Fountain Tracking Number # SP-26-006

Kroger Spoke – Site Development Plan | 702 Bandley Drive, Fountain, CO 80817

Please see below for responses to the plan review comments provided by your department. We have provided an itemized list of the comments with responses below it. Please refer to the attached drawings with revision clouds in response to the comments.

G-002

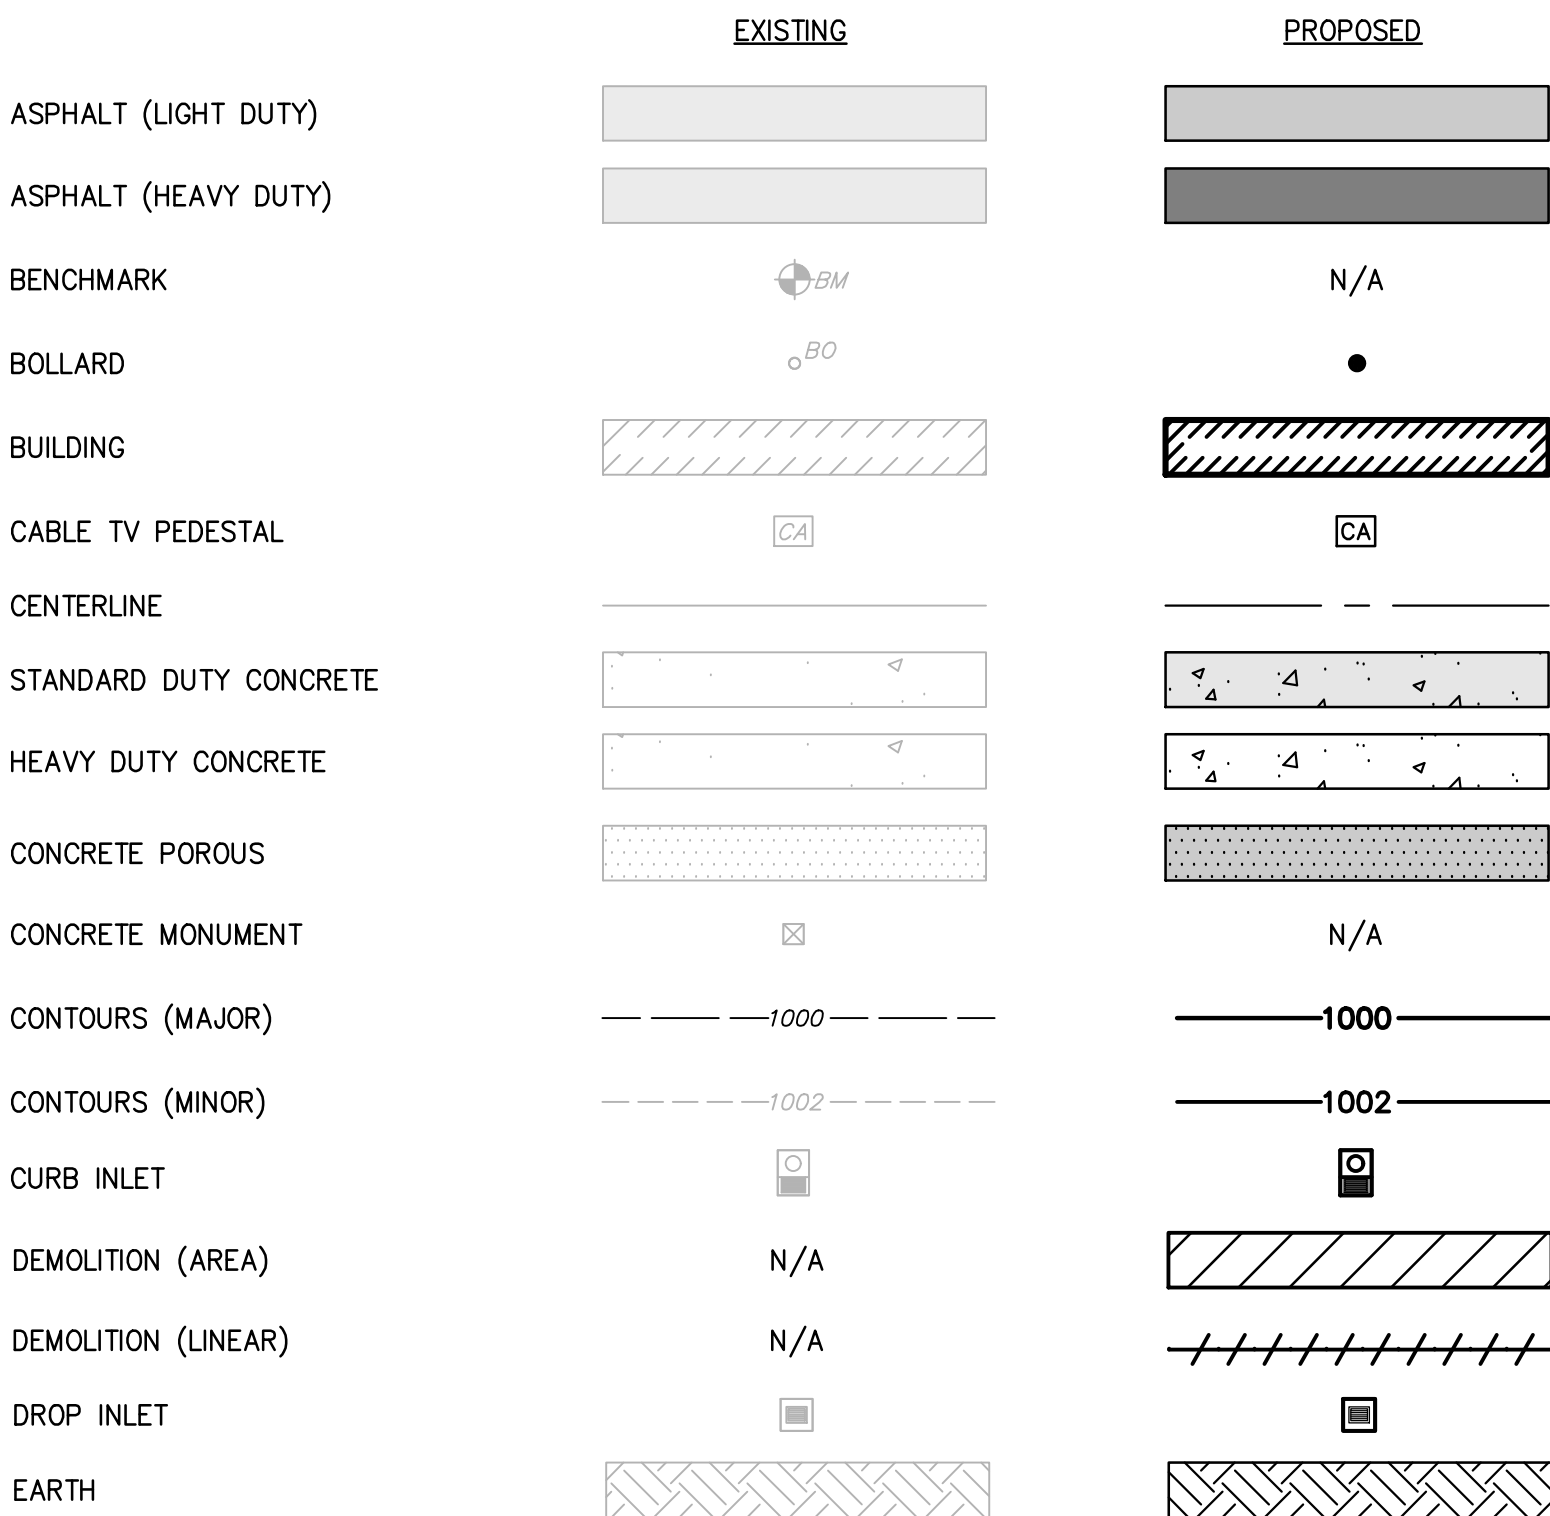
25. G-002 General Notes - Rebecca Gonzales is the engineer of record

26. G-002 General Notes - Add plat name

27. G-002 General Notes - Water is Fountain. Sanitary is Fountain San Distict (not a city entity)

28. G-002 General Notes - Revise

29. G-002 General Notes - Revise or eliminate this paragraph. not applicable to fountain.

Response: Note updated.

Response: Plat name added.

Response: Note 15 has been updated.

Response: Note removed.

Response: Note removed.

C-201A

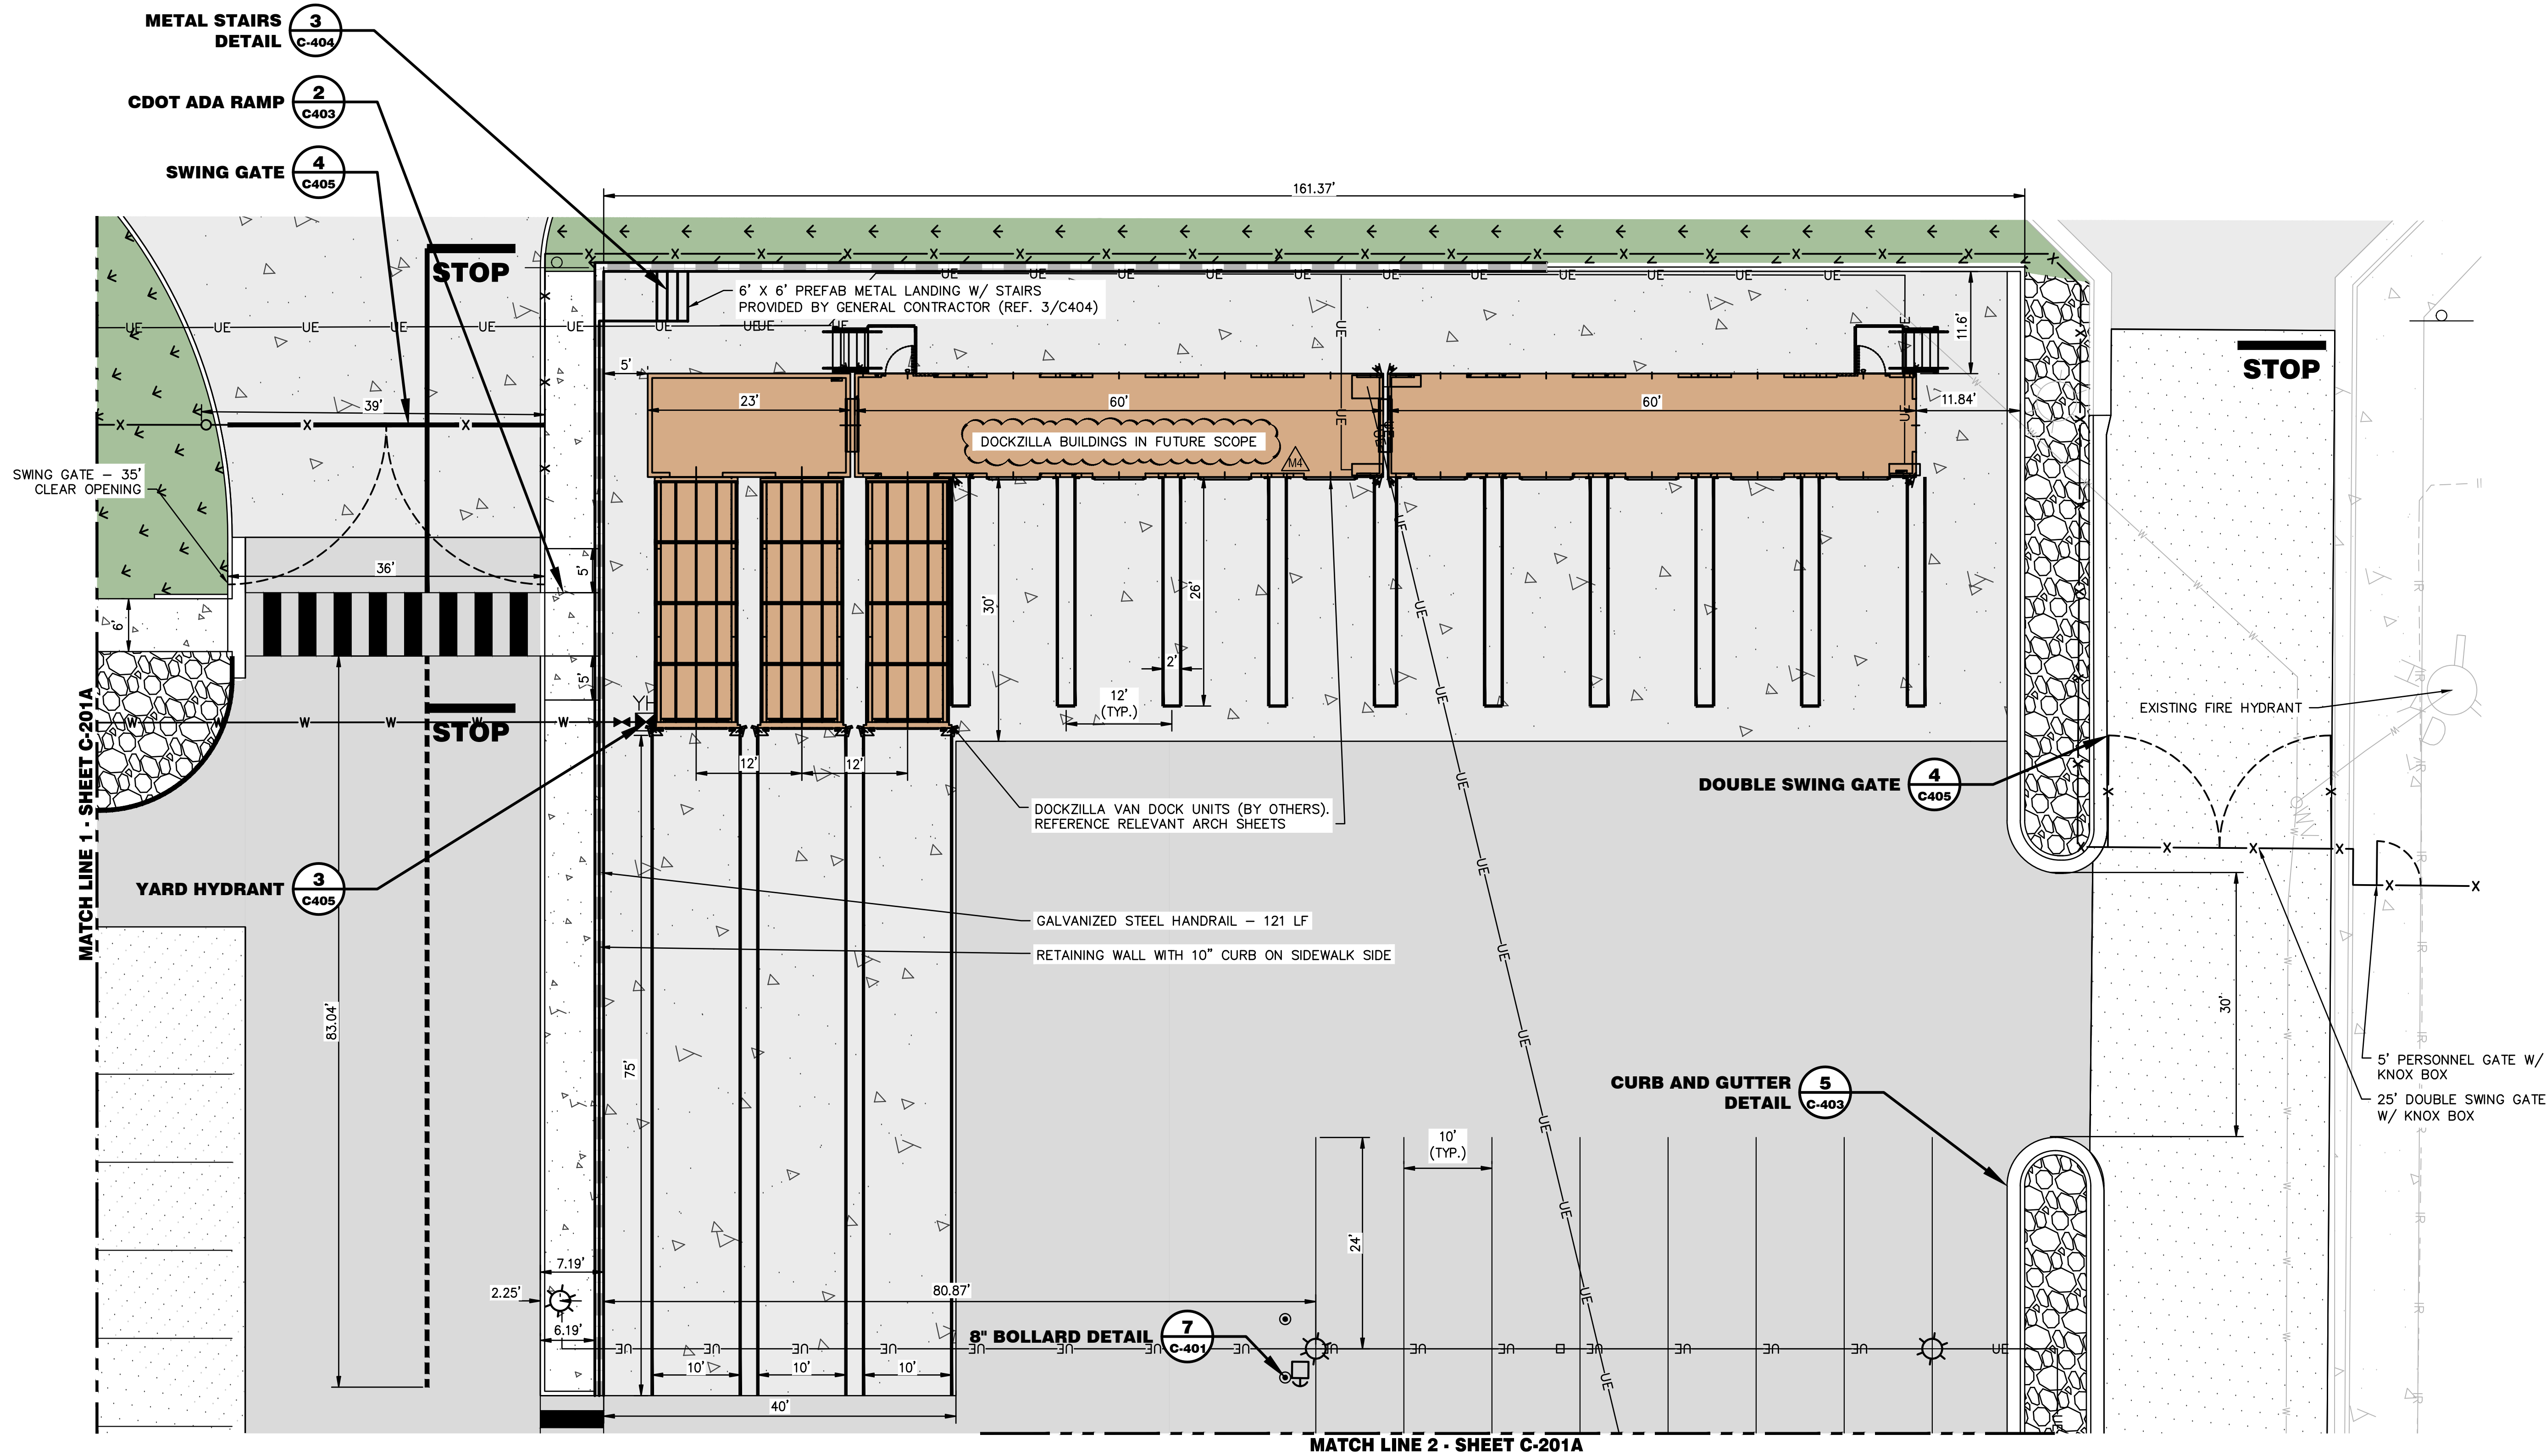
13. ADA Accessibility Note - Add the following ADA Accessibility Note to the plans:

16. Signage Note - Please add the following note: Note: Signage is not reviewed as part of the site development plan and will require a separate sign permit application.

Response: ADA Accessibility note added to sheet C-201A.

Response: Signage note added to sheet C-201A.

C-202

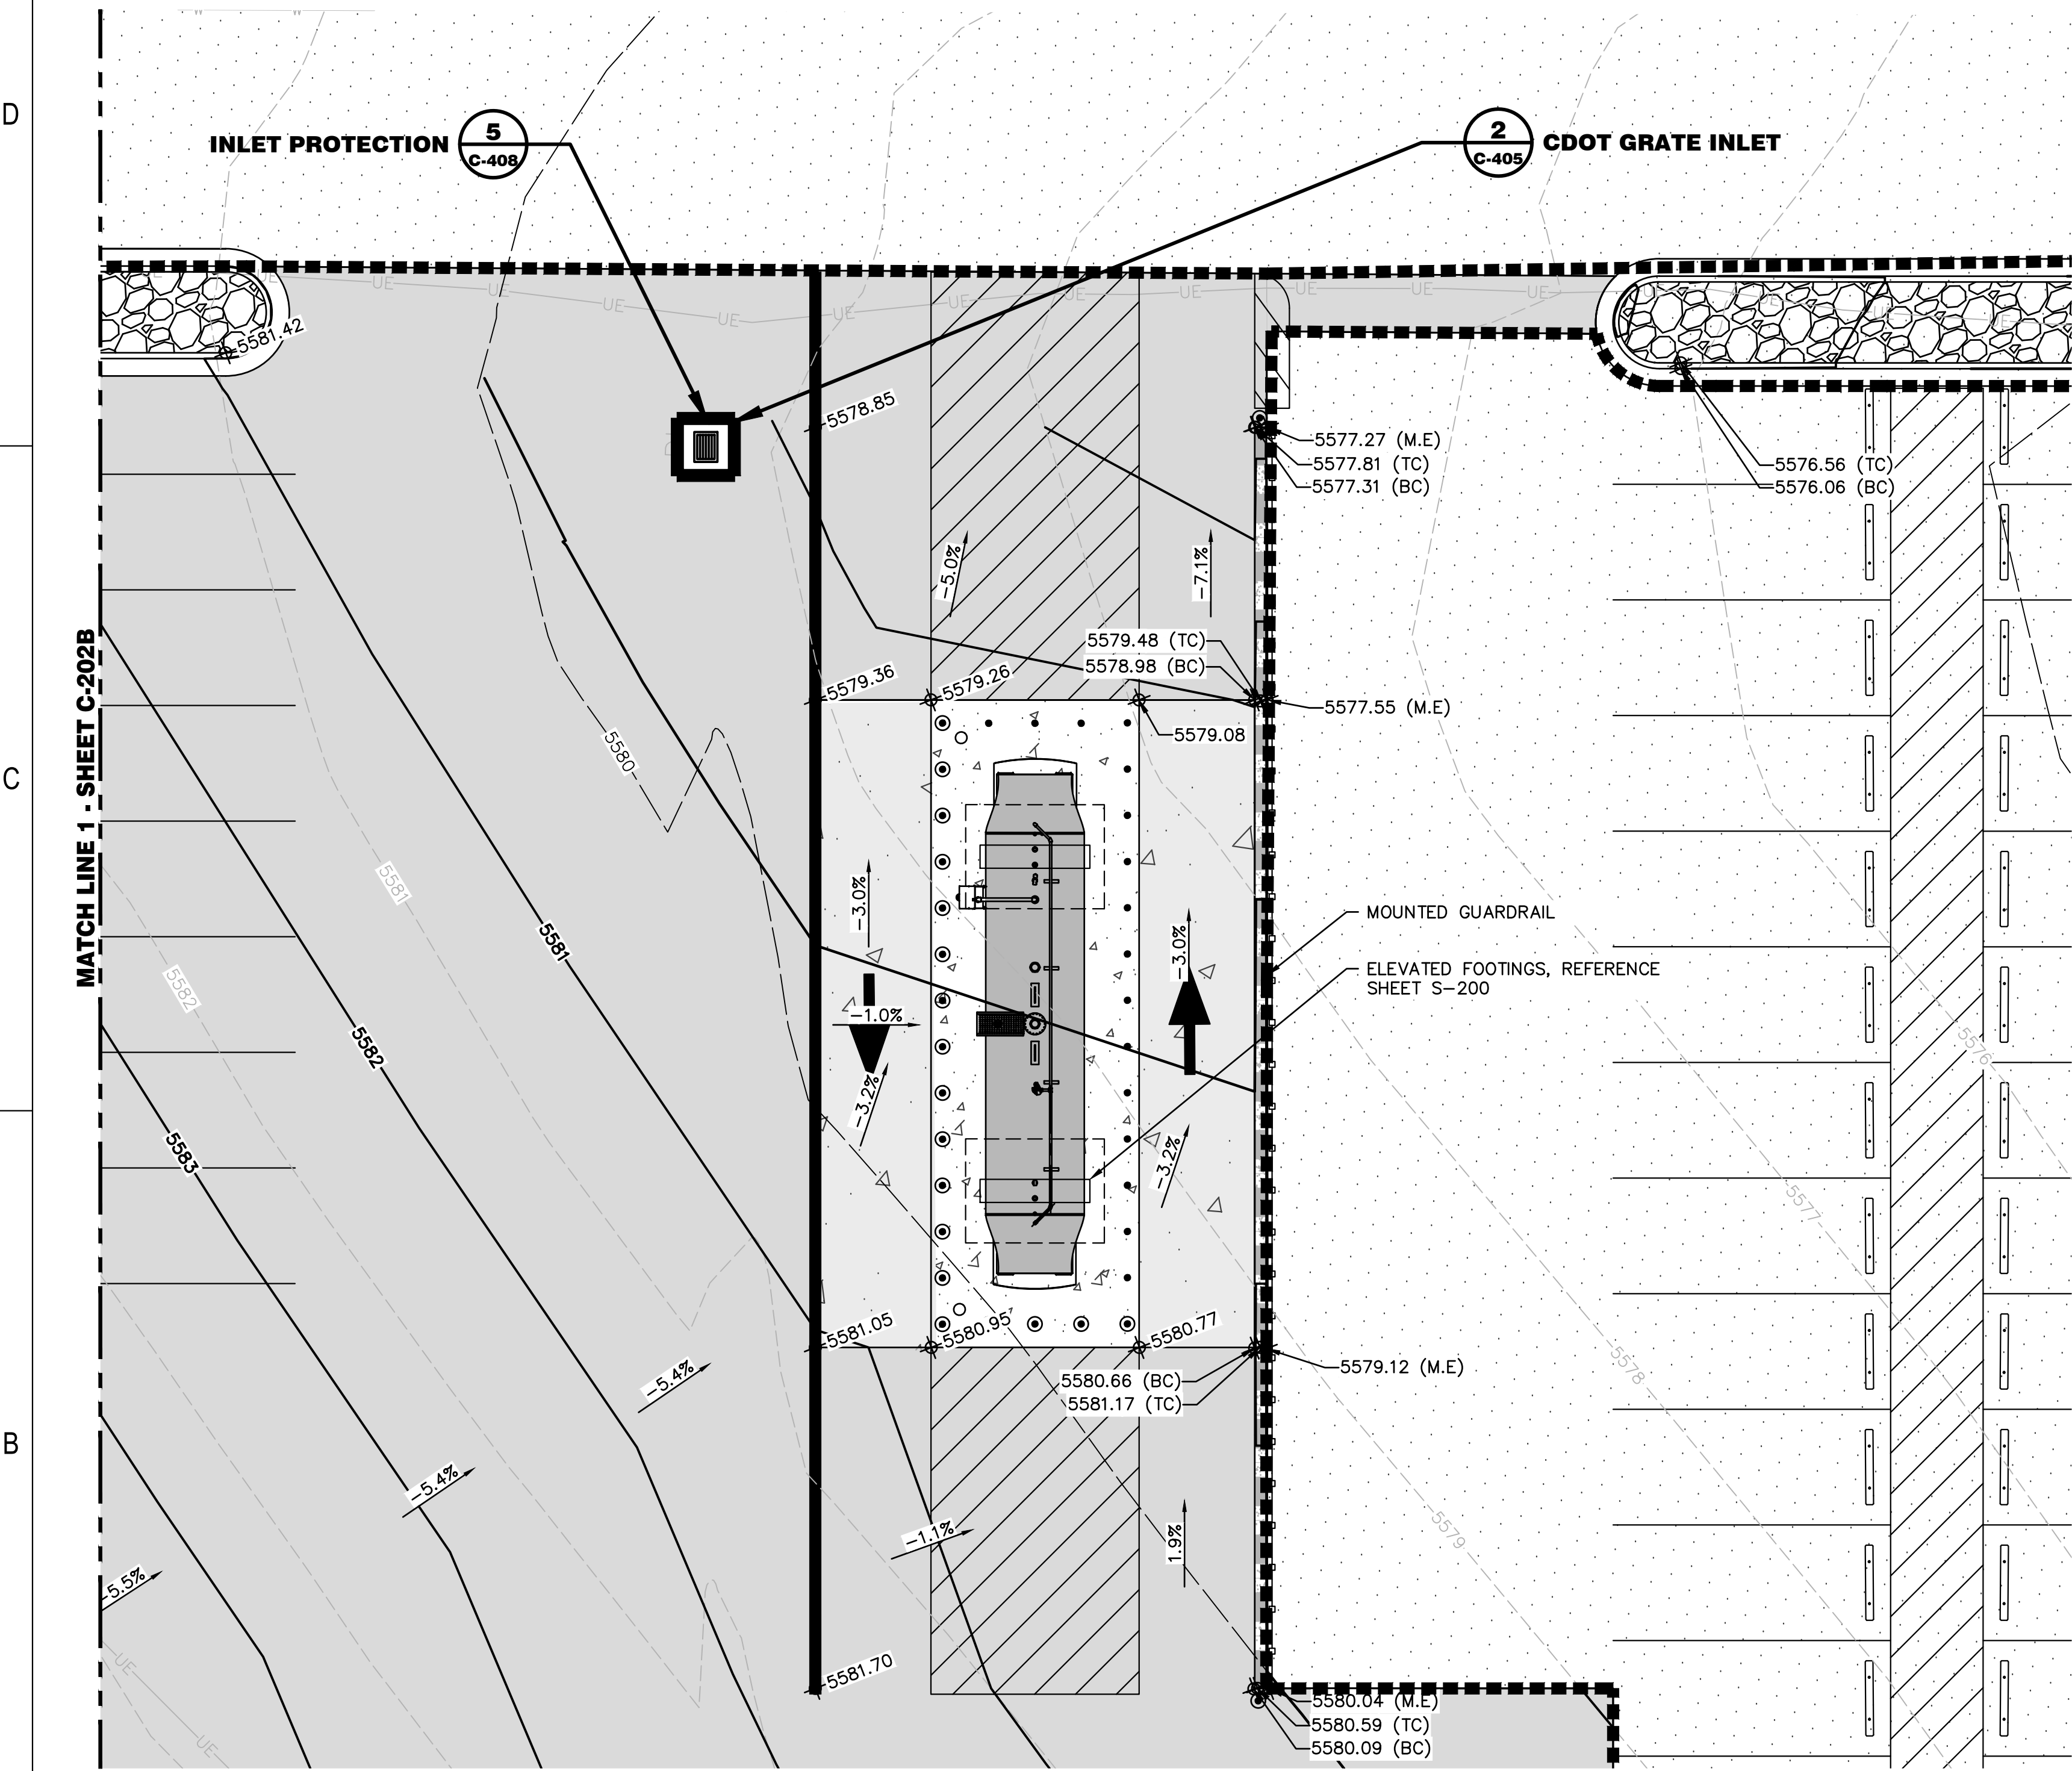
31. GEC Plans - As noted on sheet 202A, the grading and erosion control plans do not reflect Fountain stds. A review of the plans in this set has not been conducted as a result. Additional comments can be expected.

30. G-202A Detailed Grading and Drainage Plan - The grading and erosion control plans in this plan set do not follow the Fountain adopted grading and erosion control plan requirements as set forth in the Colorado Springs Stormwater Construction Manual (SCM). A review will not be conducted until such time as it follows the stds. Also, please remove all references to the County or other entities not associated with this project.

Response: GEC Plan now reflects fountain standards.

Response: Grading plan has been revised to comply with the requirements of the Colorado springs Stormwater Construction Manual (SCM)
